Environmental Assessment Report - Executive Summary

This Environmental Assessment Report (EAR) is submitted to the Minister for Planning pursuant to Section 75W of the Environmental Planning and Assessment Act 1979 (EP&A Act). Specifically this application seeks to modify Project Approval 10_0010 to account for minor external changes to the approved Dick Smith building.

Dick Smith Warehouse Facility and associated infrastructure - MP10 0010

07 SOUTH ELEVATION
TRANSPORT OFFICE

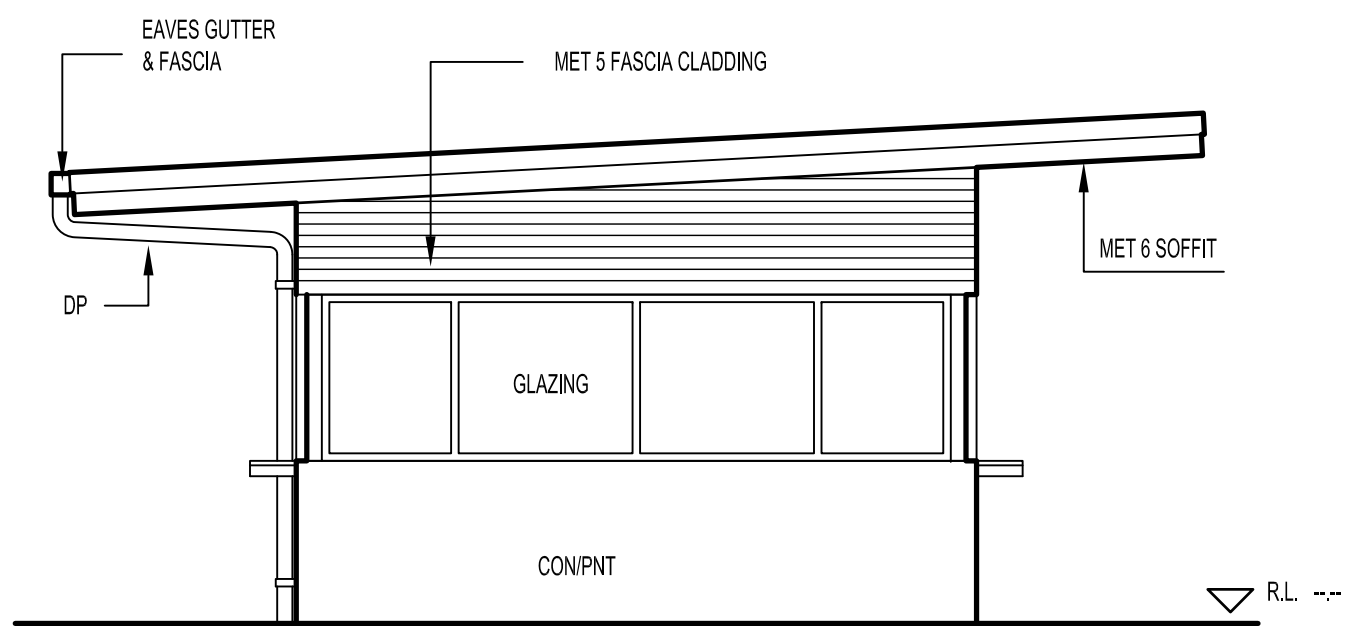
| No. | Item | Description |
|-----|-------------------------------------|---------------------------------------------------------------------------------------------------------------------------------------------------------------------------------------------------|
| 1 | Addition of a gatehouse | New item introduced for security purposes. |
